### Hearing Action Points

Application by Norfolk Boreas Limited for an Order Granting Development Consent for the Norfolk Boreas Offshore Wind Farm Project.

Actions arising from the Offshore Effects including the draft Development Consent Order hearing held at Blackfriars Hall, St Andrew's Plain, Norwich, NR3 1AU on Wednesday 22 January 2020.

Relationship of Offshore Plans secured by the DCO (Project Interconnector DMLs)

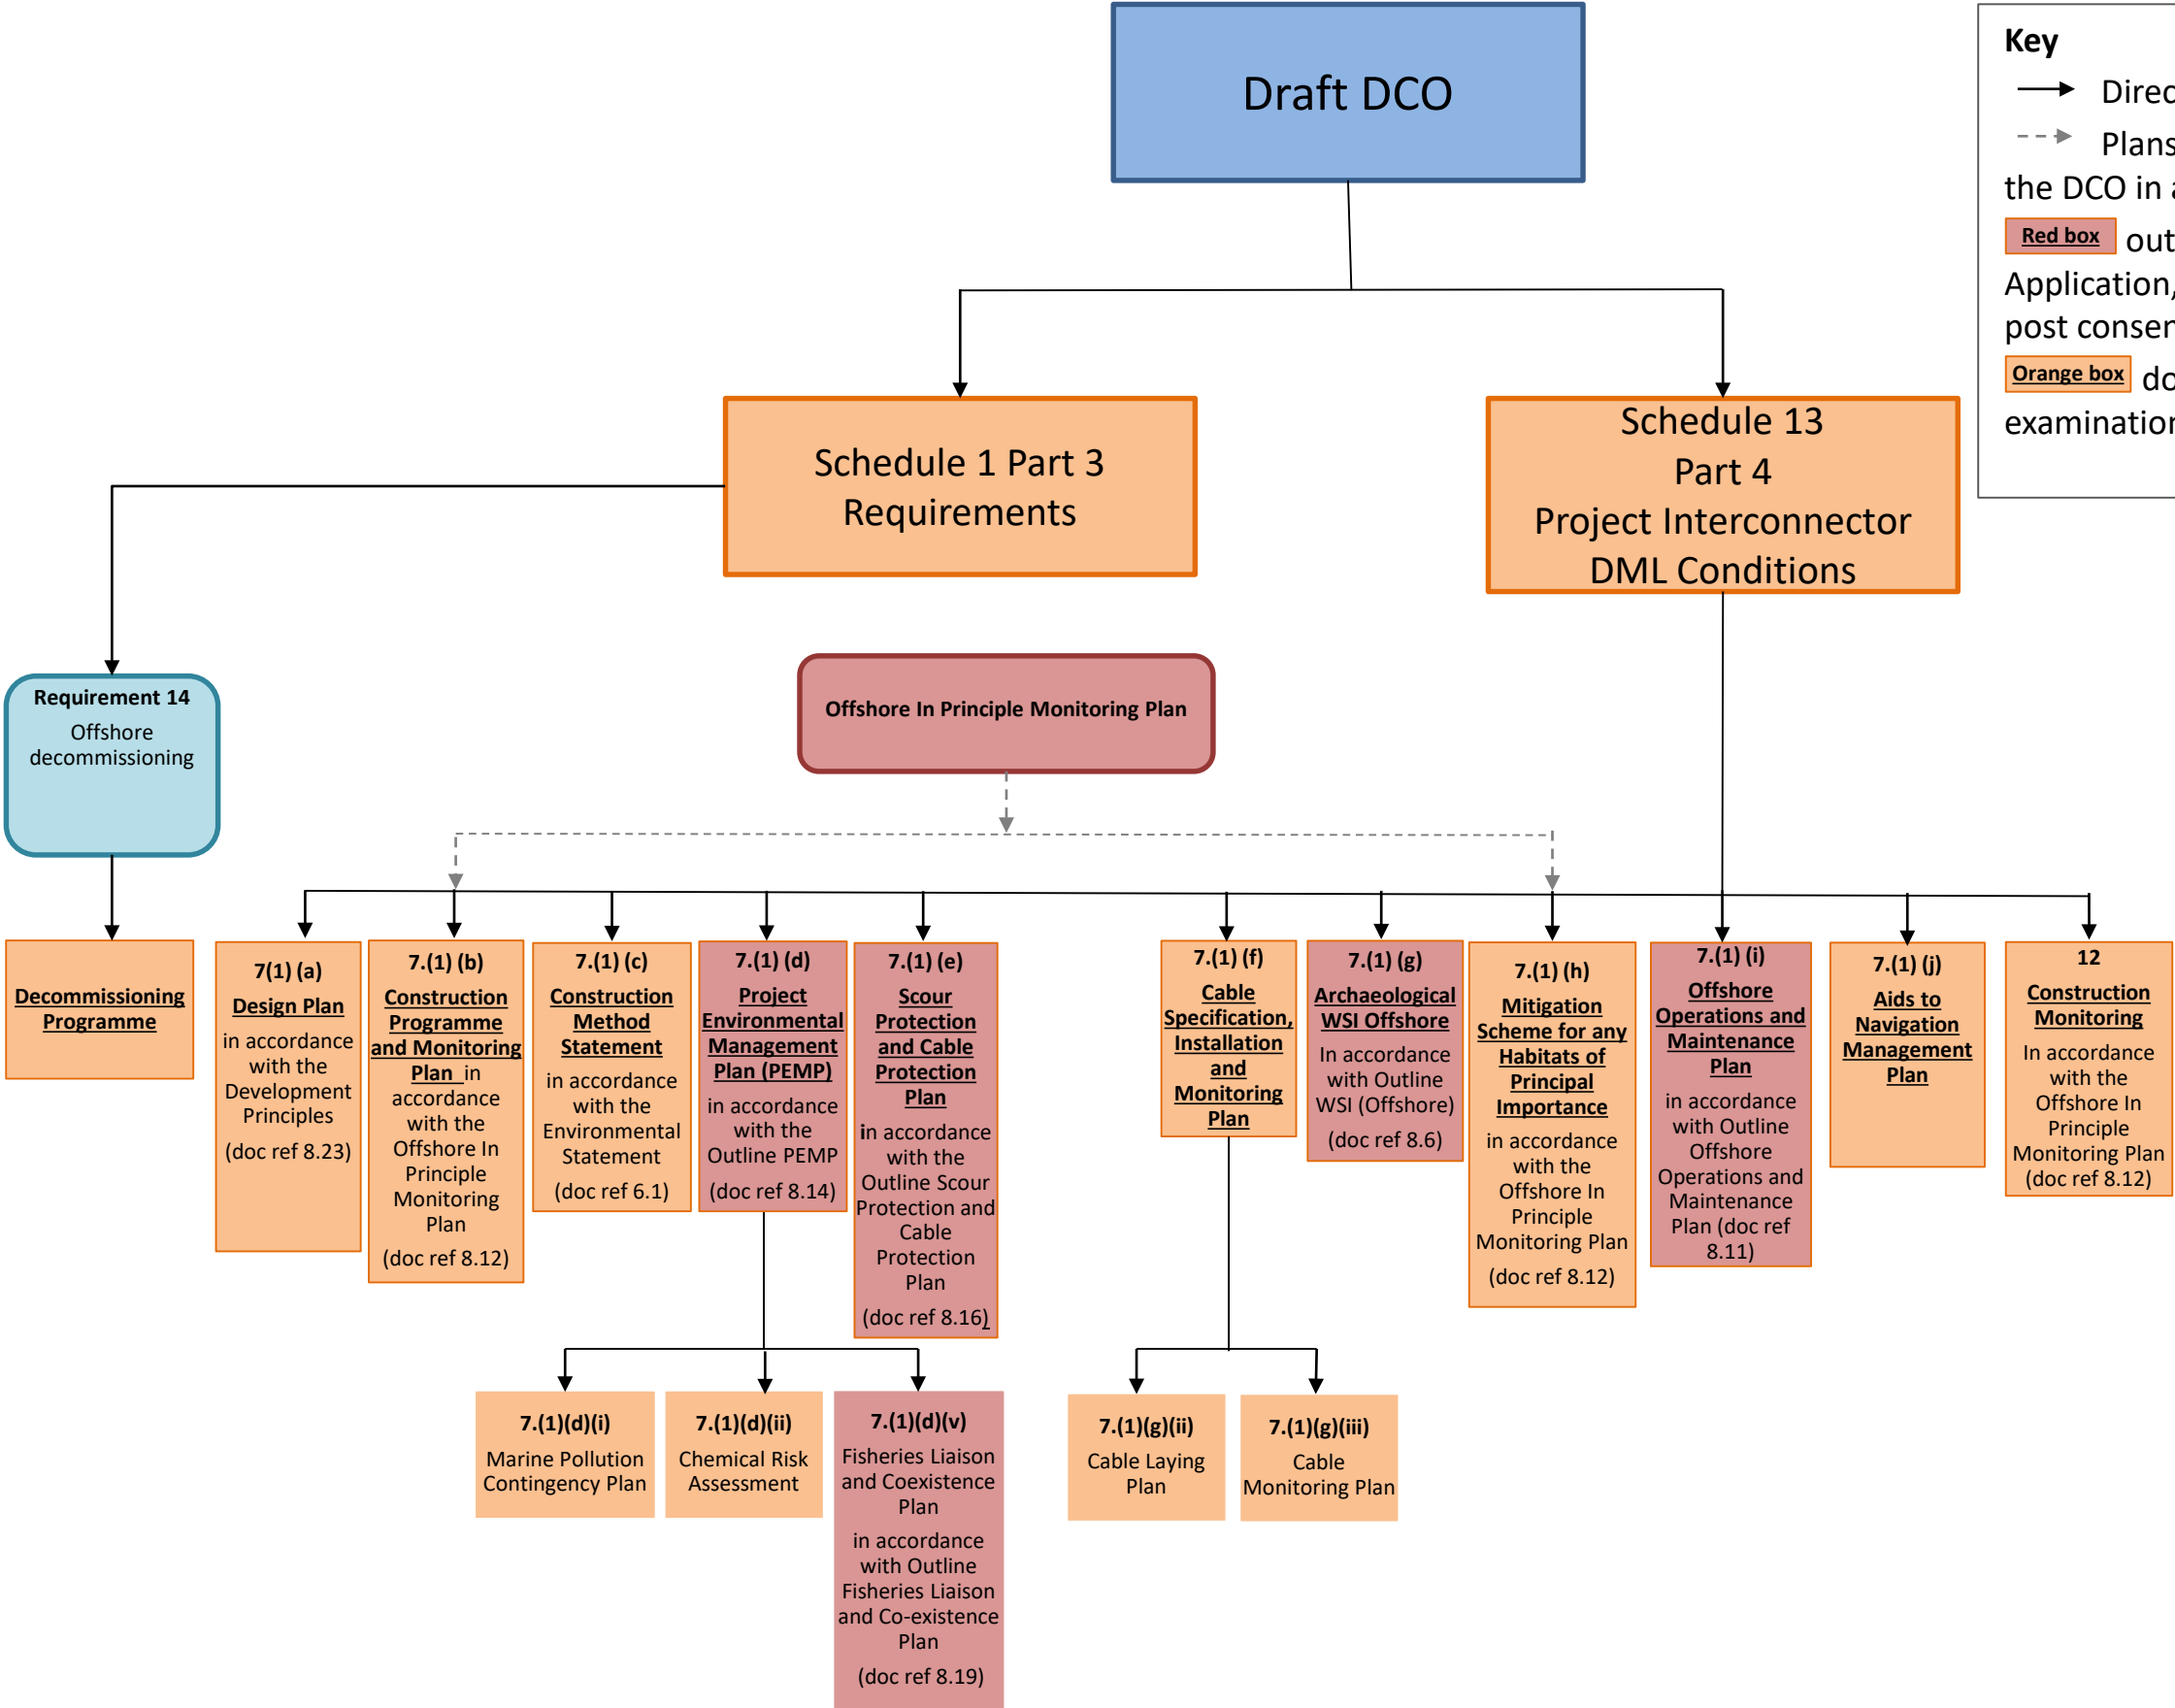
2.	Submit note to clarify how the offshore In Principle Monitoring Plan relates to the DCO and to the DML Conditions and to the various plans secured under the DML conditions (currently shown as a partial pecked line relationship in the [APP-022] diagrams) and what cross-referencing is necessary.	Applicant	D4
